DEVELOPMENT REVIEW COORDINATOR
POST APPROVAL PROJECT CHECKLIST

Project Name:	Interior Renovation/ Addition	Project ID:	2015-138
Address:	35 Pleasant Street	CBL:	C39 F023001
Applicant:	Lauren Reiter		
Planner:	Shukria Wiar

On April 11, 2016, the Planning Authority approved with conditions a Level II site plan for a building addition to the structure at 35 Pleasant Street. The proposed building addition expands the existing residential use by adding one story to the rear of the building and expands the building over the existing parking area to create a garage and upper floor residential space. This project includes a construction analysis from the construction company outlining how the building expansion to the property lines can be achieved from the applicant's property and will not affect adjoining properties during construction. The applicant has a construction easement along the property boundary for 14 South Street. The decision is based upon the application, documents and plans as submitted by and prepared by Lauren Reiter with a revised date of 03.24.2016. The proposal was reviewed for conformance with the standards of Portland's site plan ordinance.

A101

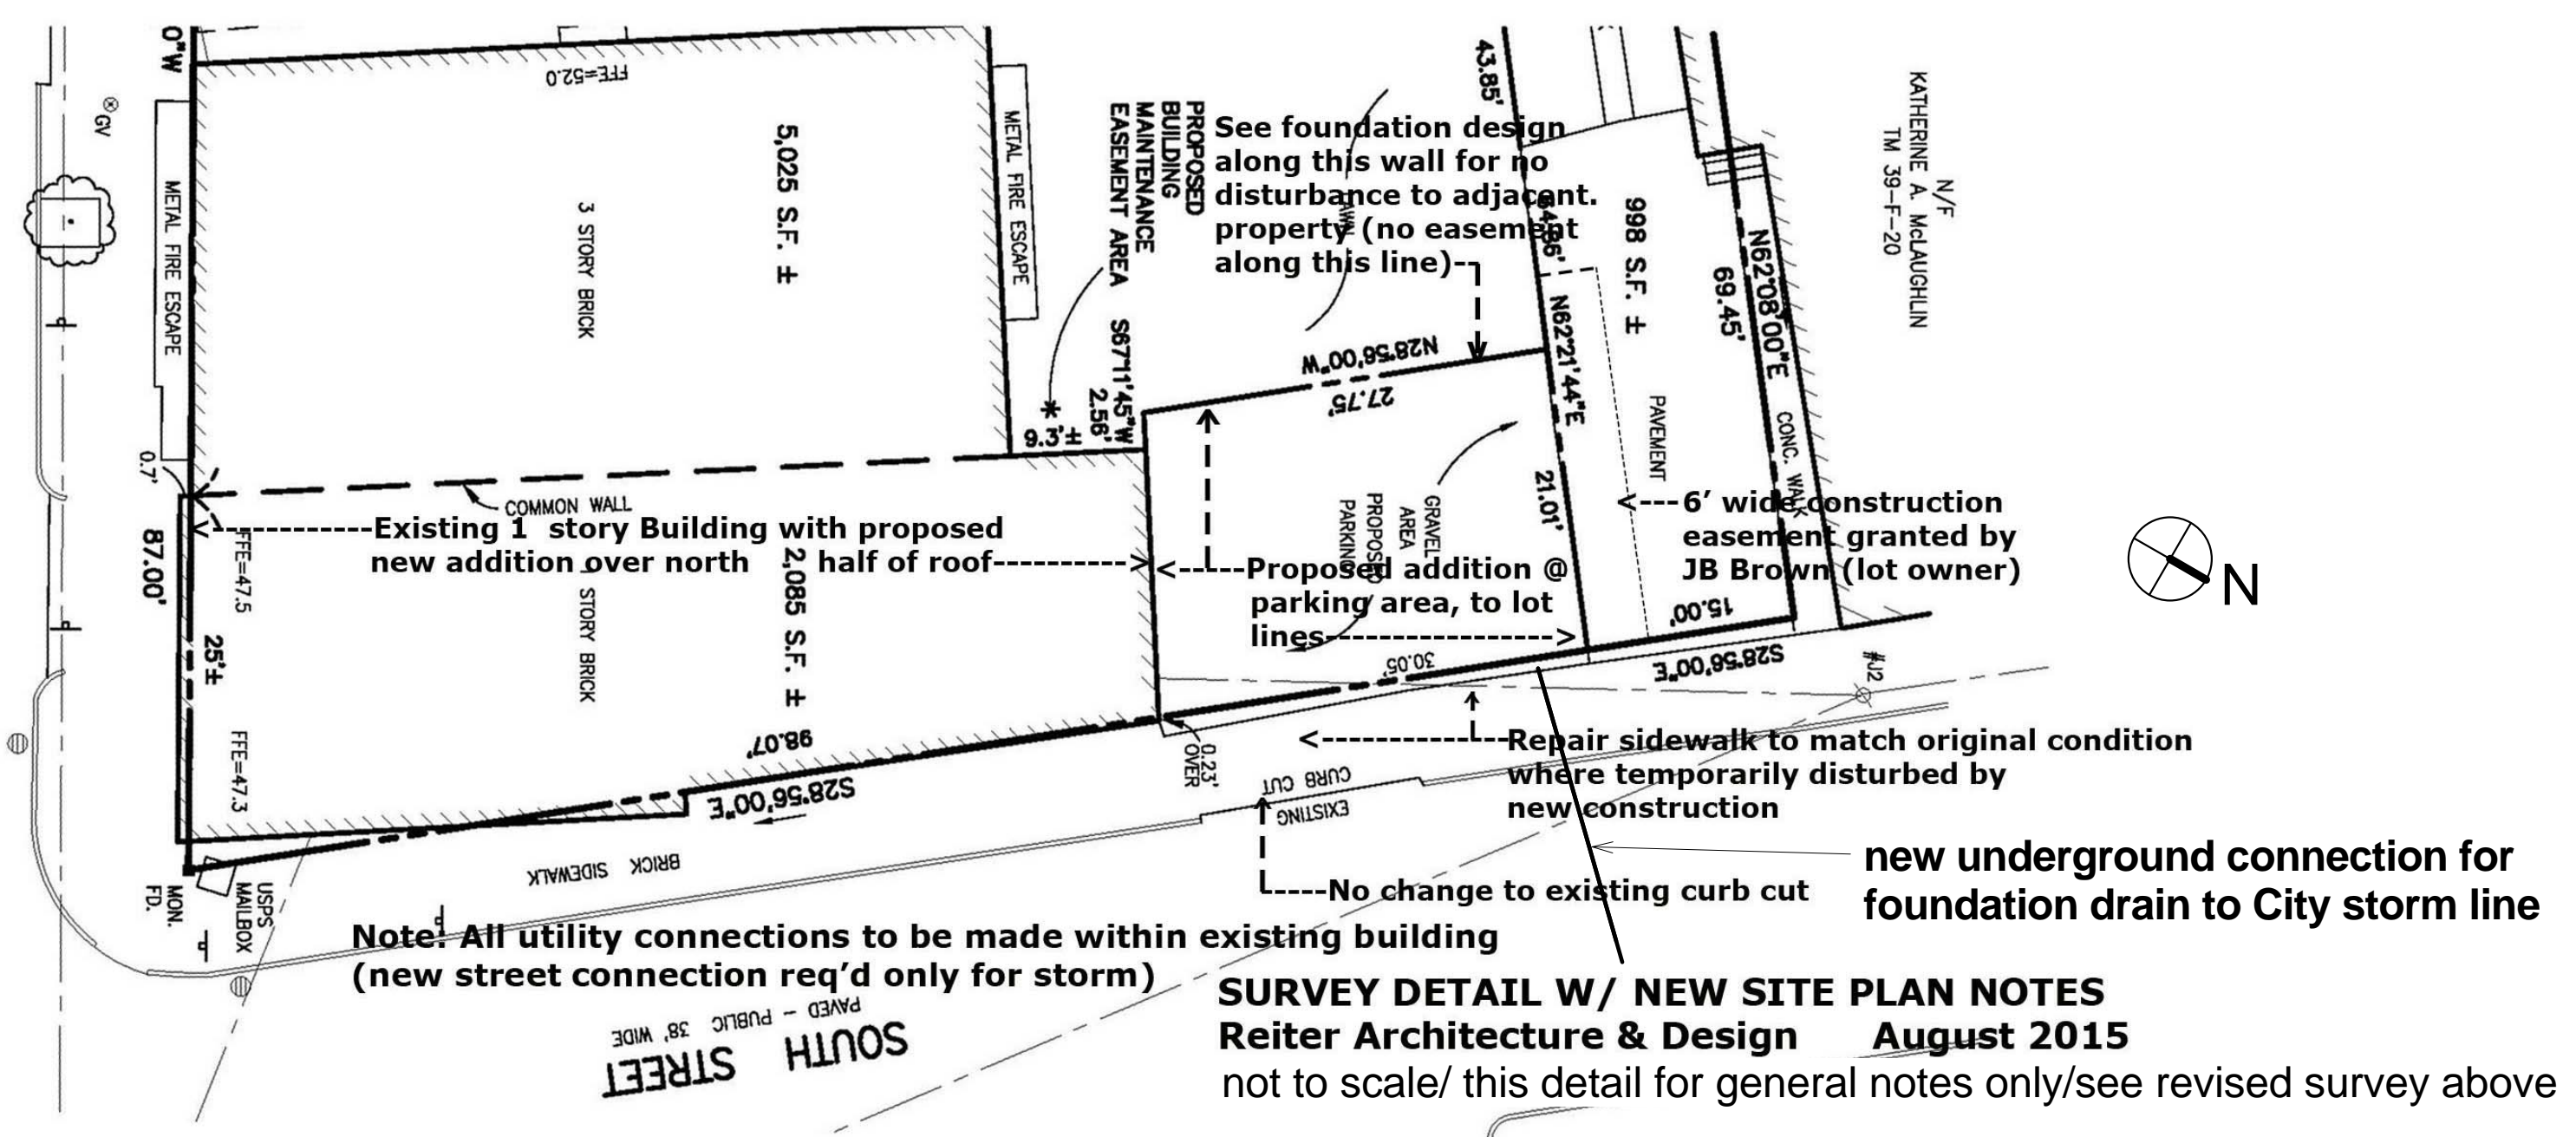
1. The applicant shall cleanly cut any disturbed roots of the Elm tree, on the abutters property at 37 Pleasant Street during construction and be watered if conditions are dry. Deadwood shall be pruned next dormant period as not to attract elm bark beetle to the new wound wood. The applicant shall follow 'best management practices', refer to <http://www.treesaregood.com/treecare/resources/ConstructionDamage.pdf>.
2. Based upon Lauren Reiter's email dated 03.28.2016, the proposed garage will be a two bay garage (the two bays on the southerly side of garage and in line with existing curb cut) for the parking of motor vehicles. The third bay closest to the northerly property line shall not be used for motor vehicle parking space. The doors for the third bay shall not swing onto the City's right-of-way.
3. The site work and general notes #1 and #4 on Plan A101 shall be deleted from the plan.
